Date: January 5, 2024

Response to Comments

Project Name: Undi Commerce Park
 Project File Number: PA 22008
 Review Completion: July 18, 2023

**UNDI COMMERCIAL ENGINEERS**  
 1400x Smokey Point Blvd, Marysville, WA 98271  
 A PORTION OF SECTION 33, TOWNSHIP 31 NORTH, RANGE 05 EAST, W.M.  
 Concept Water Plan

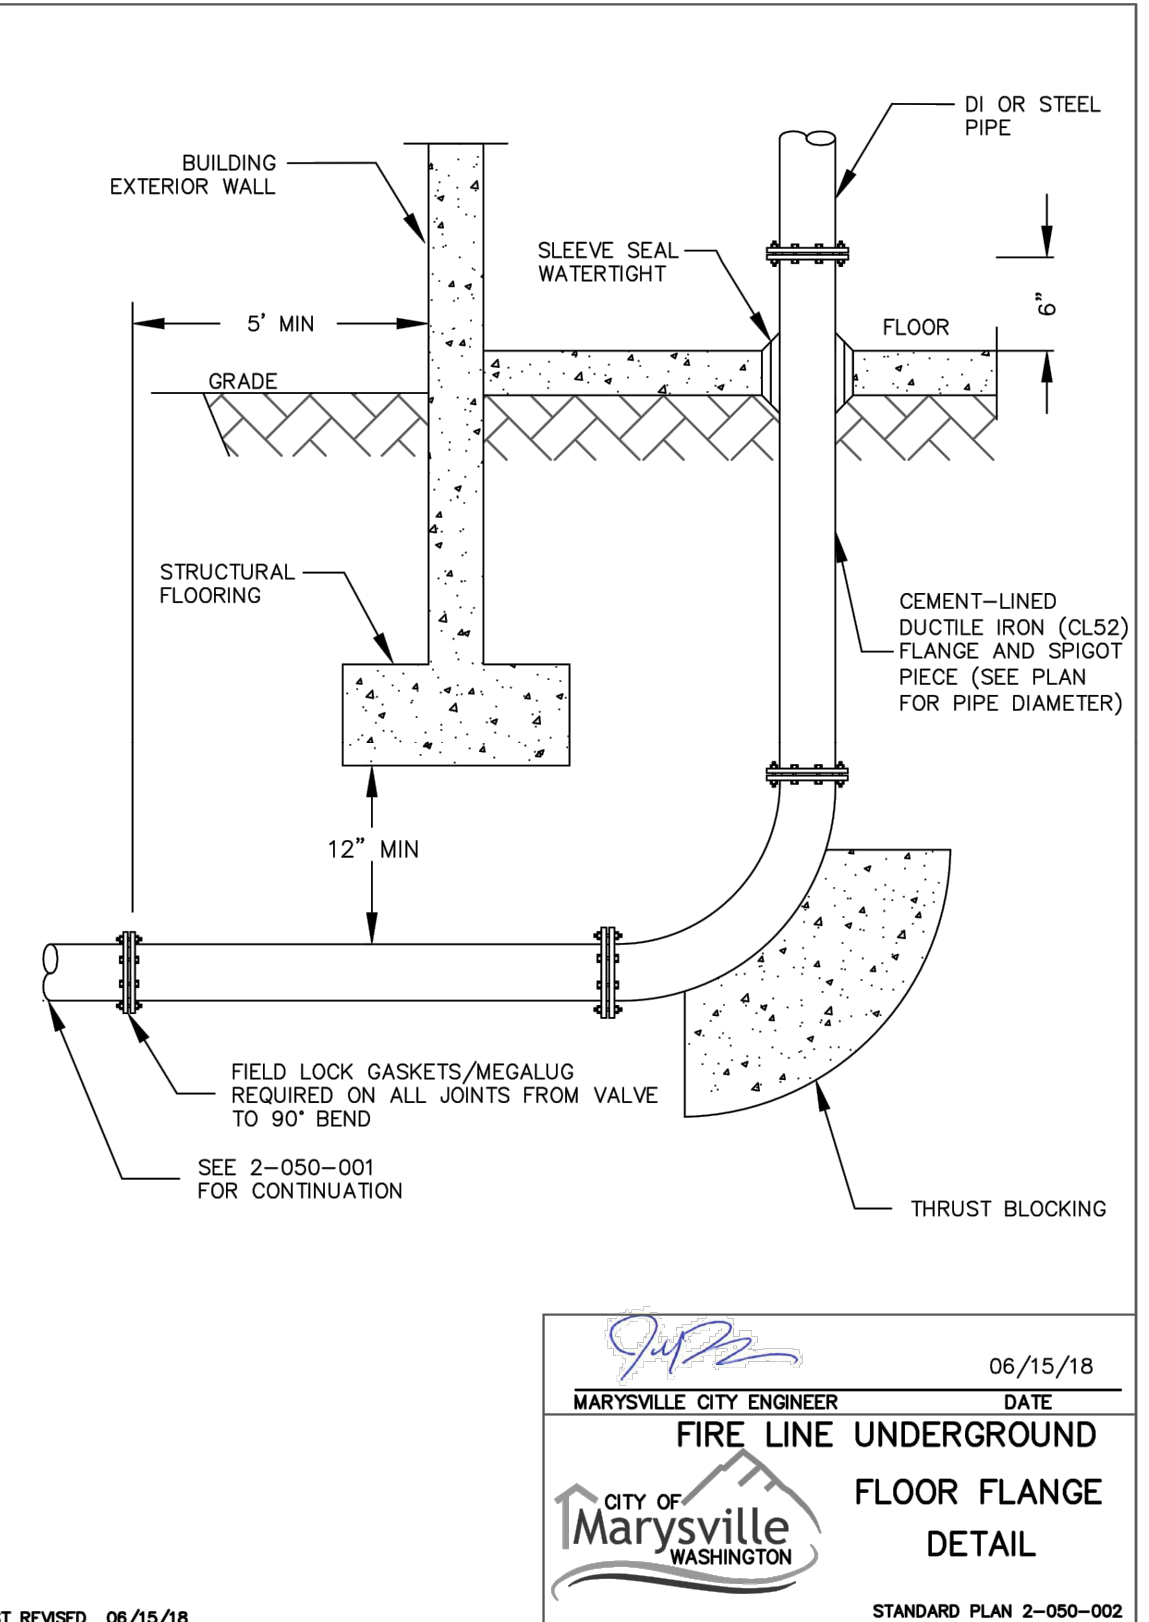
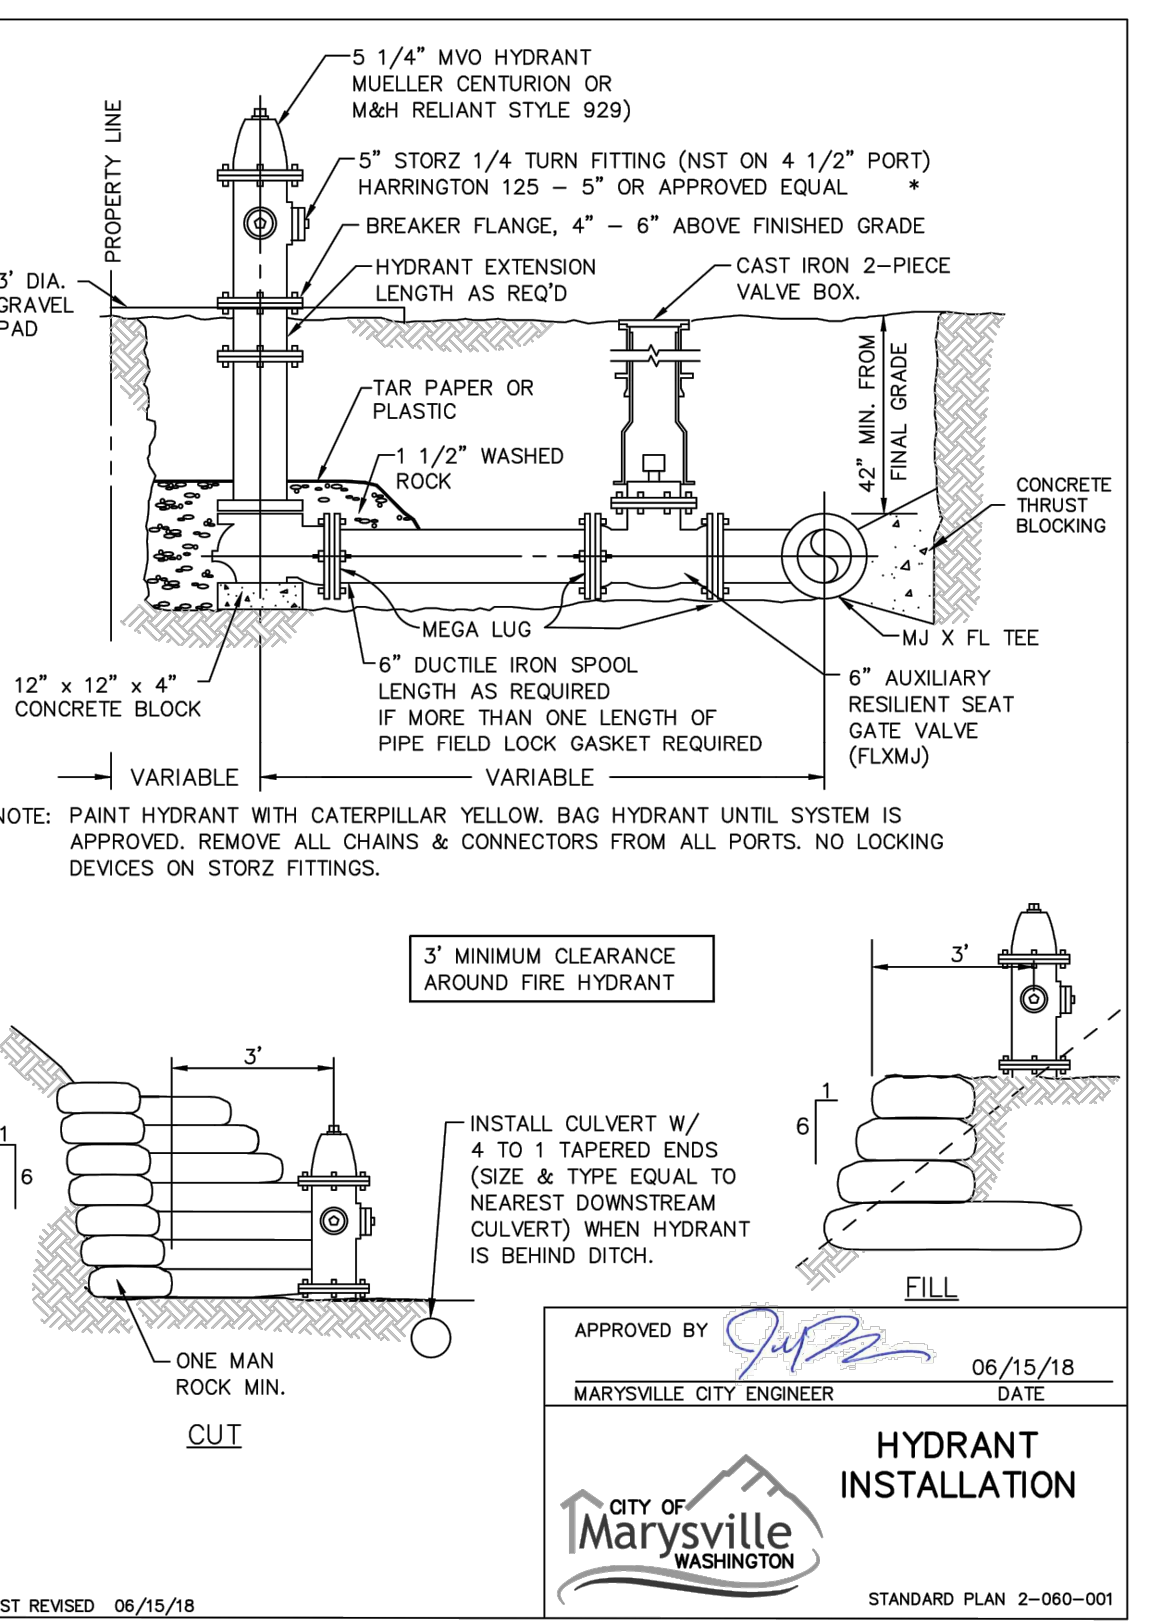
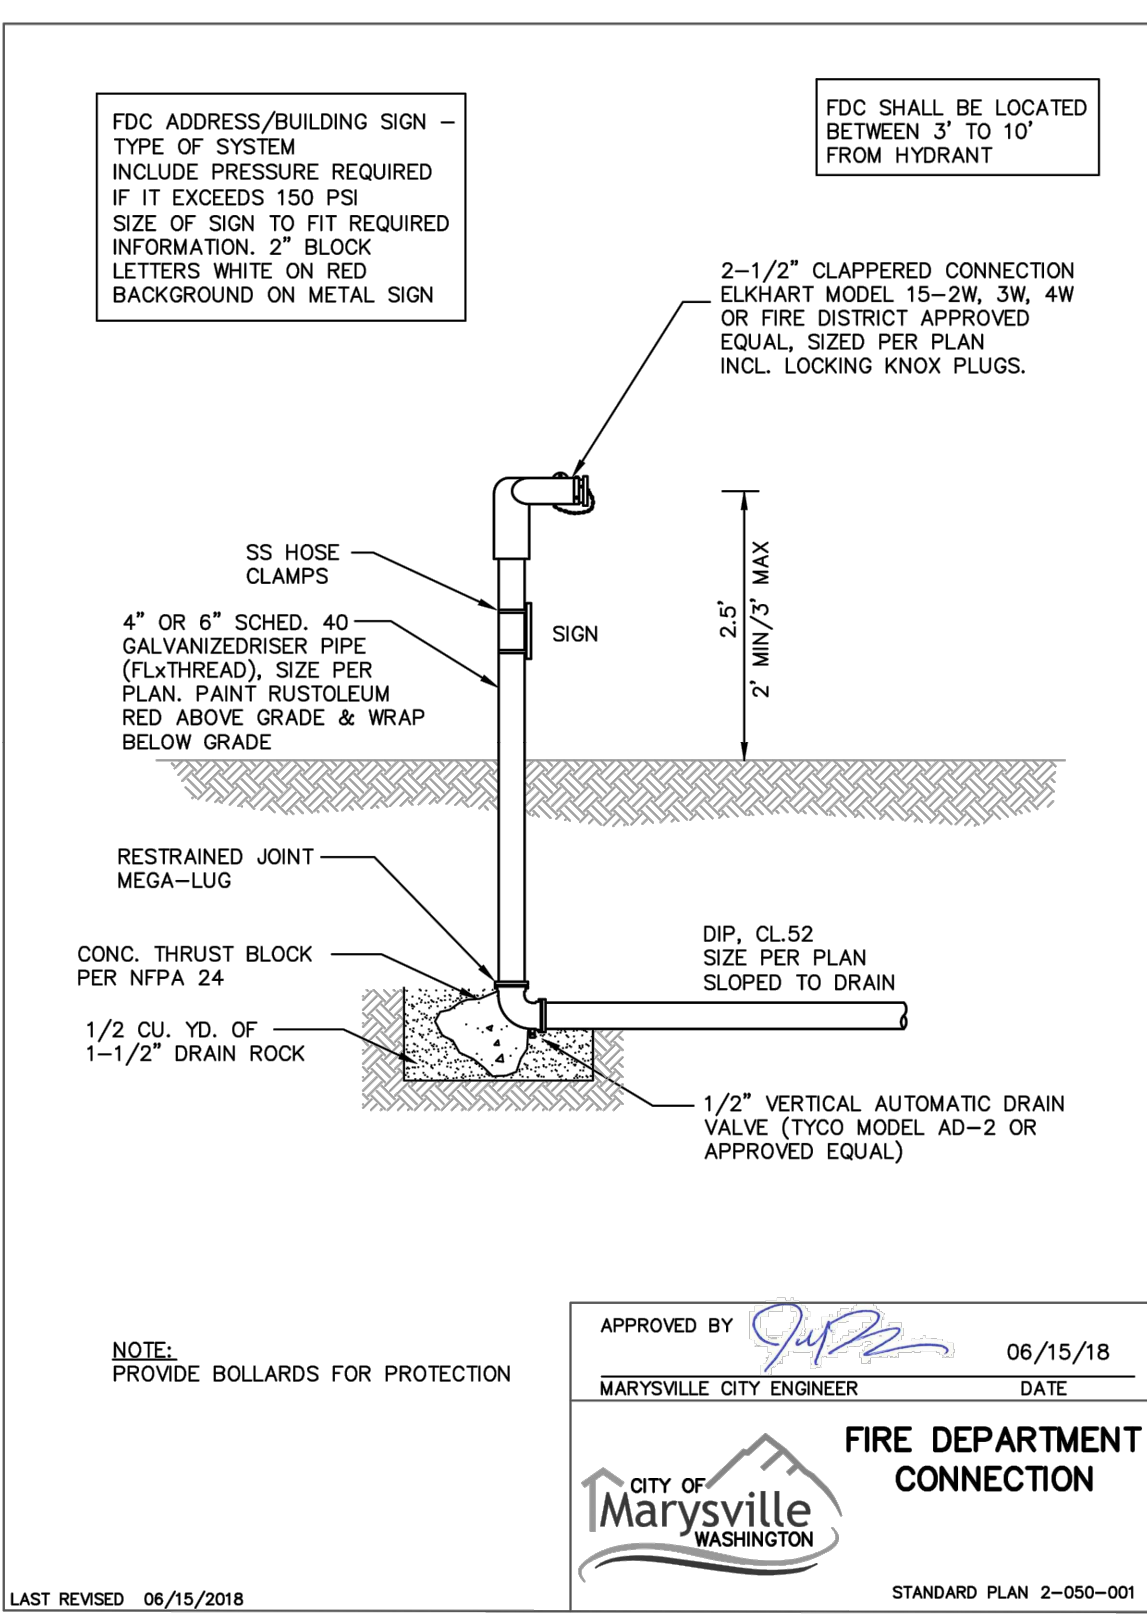
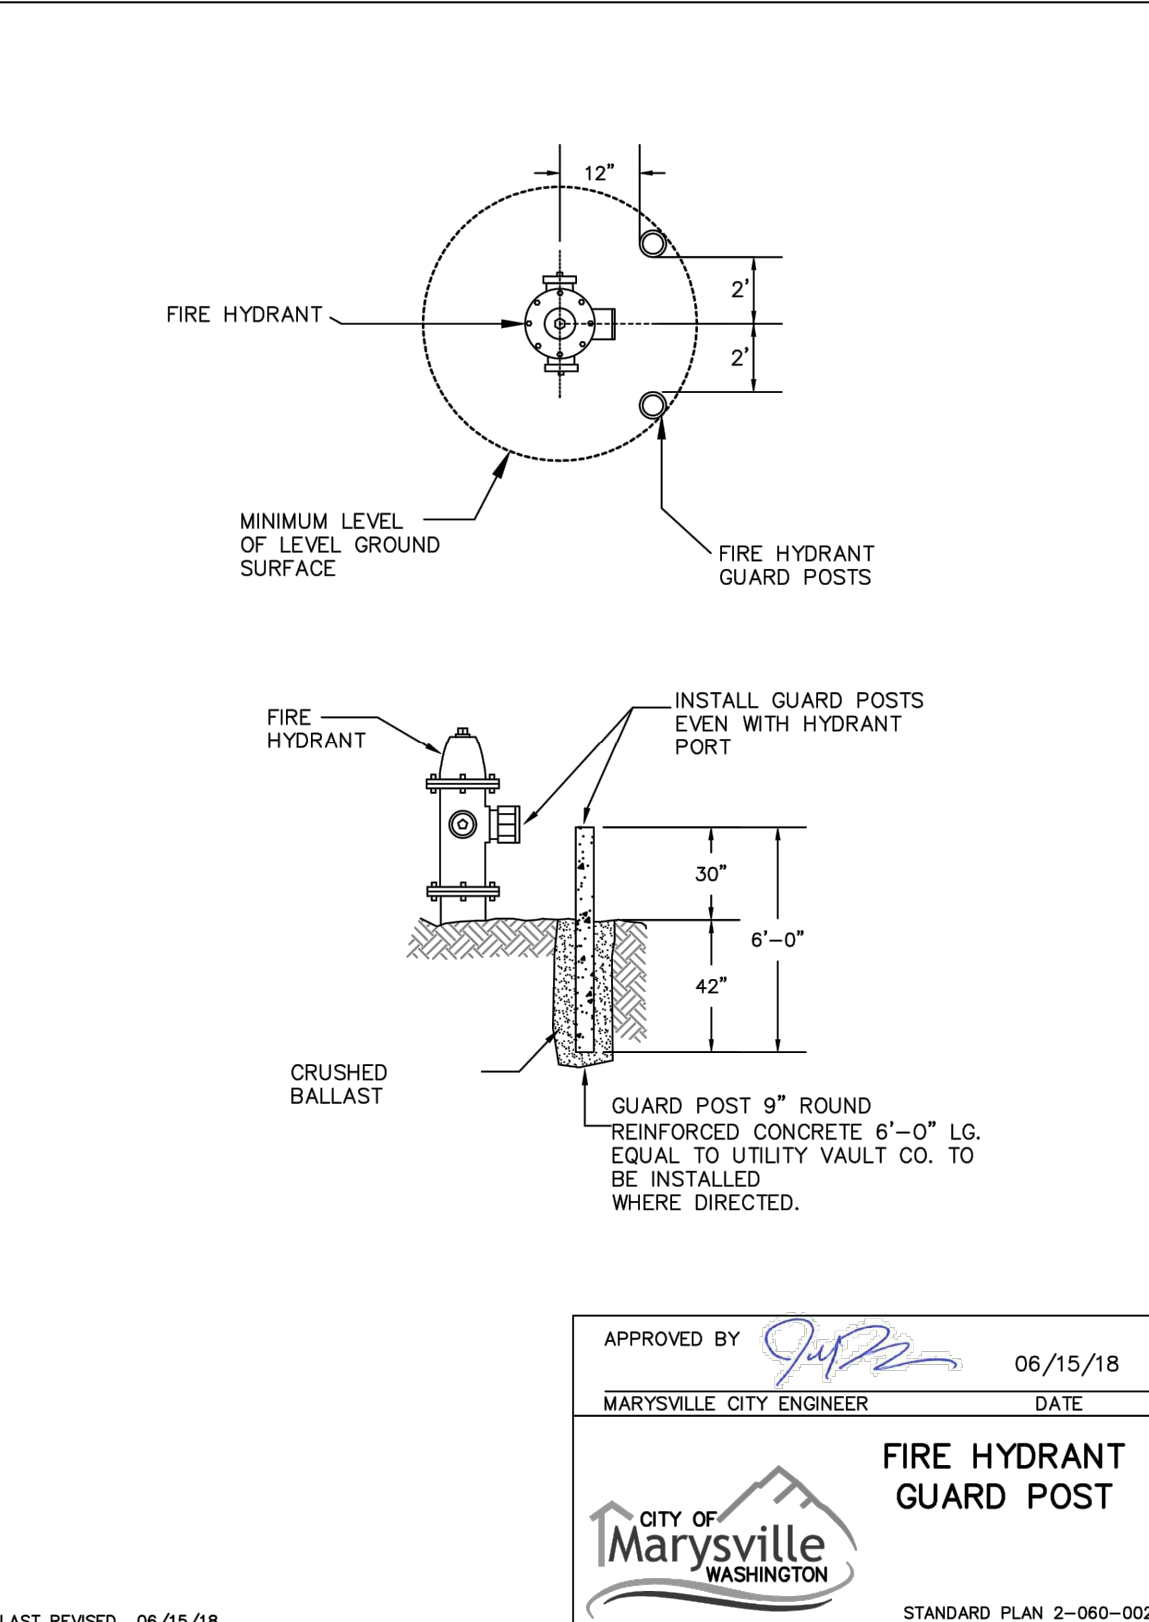
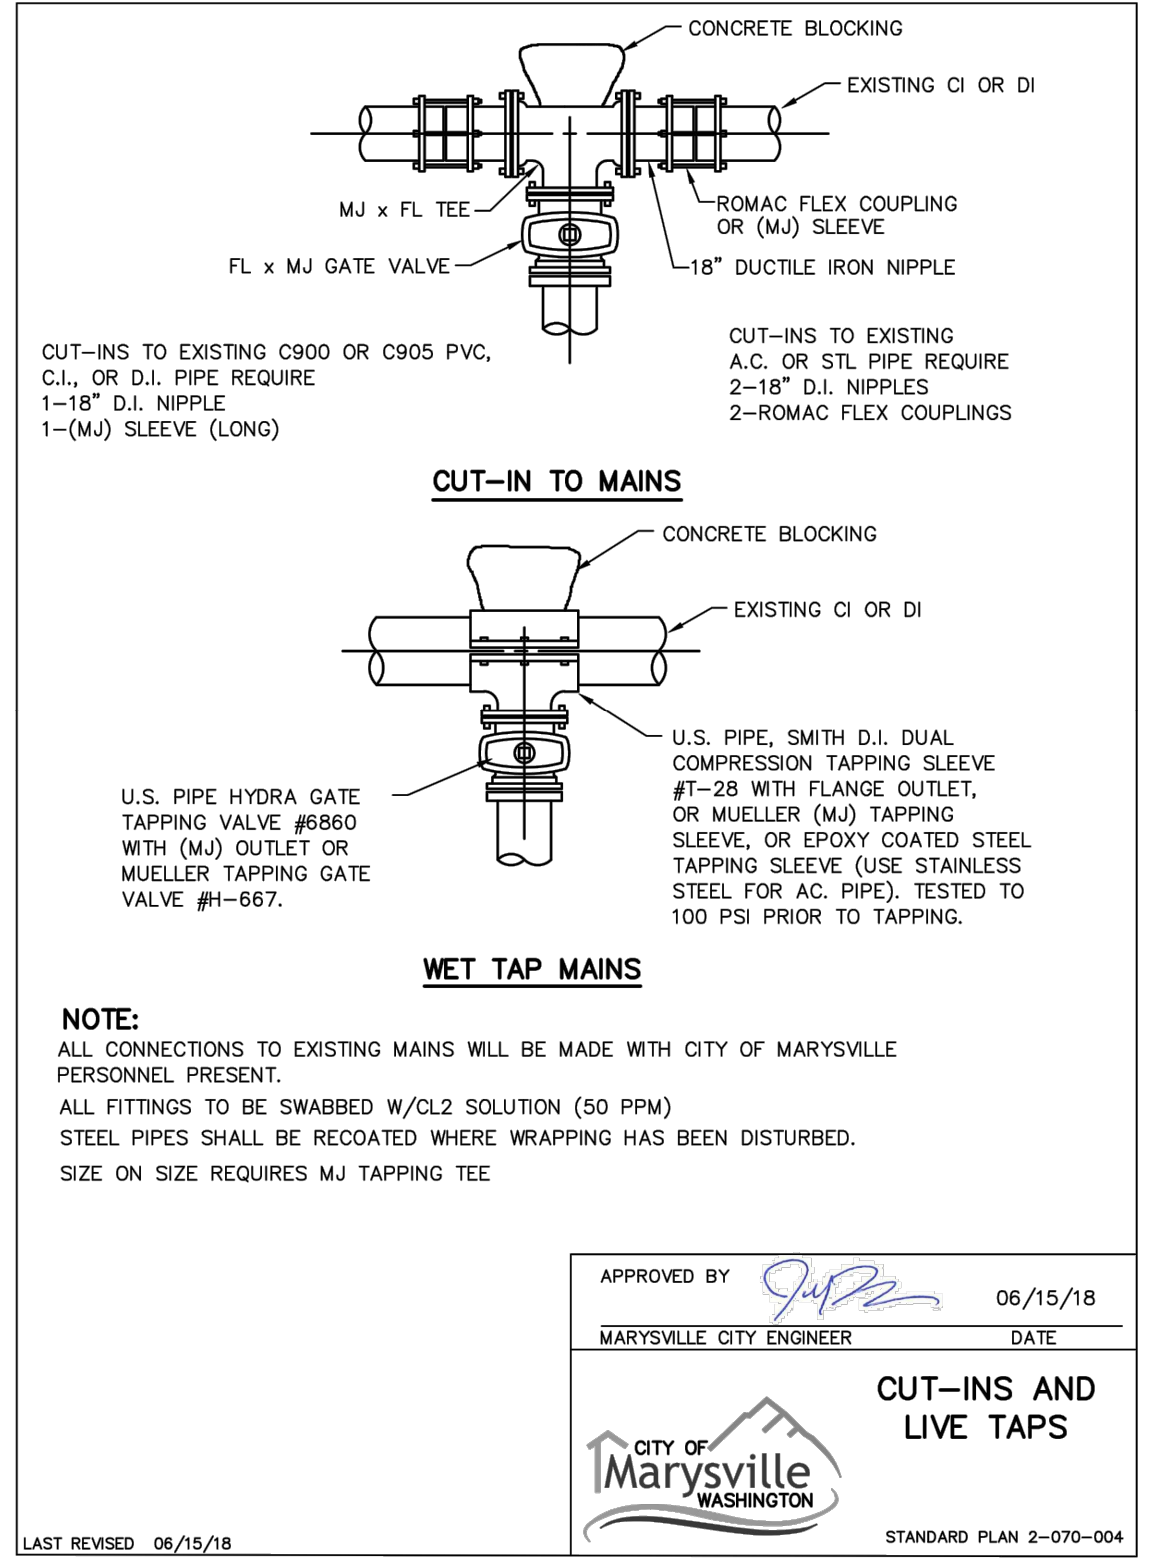
<p>18. STA 0+00 east aisle tie in change to live tap.</p>	<p>Live tap now noted.</p>
<p>19. Water main tee located between building K and D add 12" gate valve</p>	<p>Additional gate valve has been added here, sheet C8.</p>
<p>20. N=414182.5, E=1311849.3 install 8" gate valve on line going to west</p>	<p>Gate Valve has been added here on line running west.</p>
<p>21. N=414733.5, E=1311168.1, what are the locations of the 3 gate valves on the cross</p>	<p>Gate valve symbols have been added.</p>
<p>22. Locations for water services and meters both domestic and irrigation along with appropriate backflow prevention are not shown</p>	<p>These will be provided with construction plans and specific building designs. (we do not yet know where fire rooms/etc. will be located yet)</p>
<p>23. Do not see locations of fire lines or FDC. All fire lines will require a valve at</p>	<p>Thank you. Noted. Will be provided with construction plans for building construction.</p>
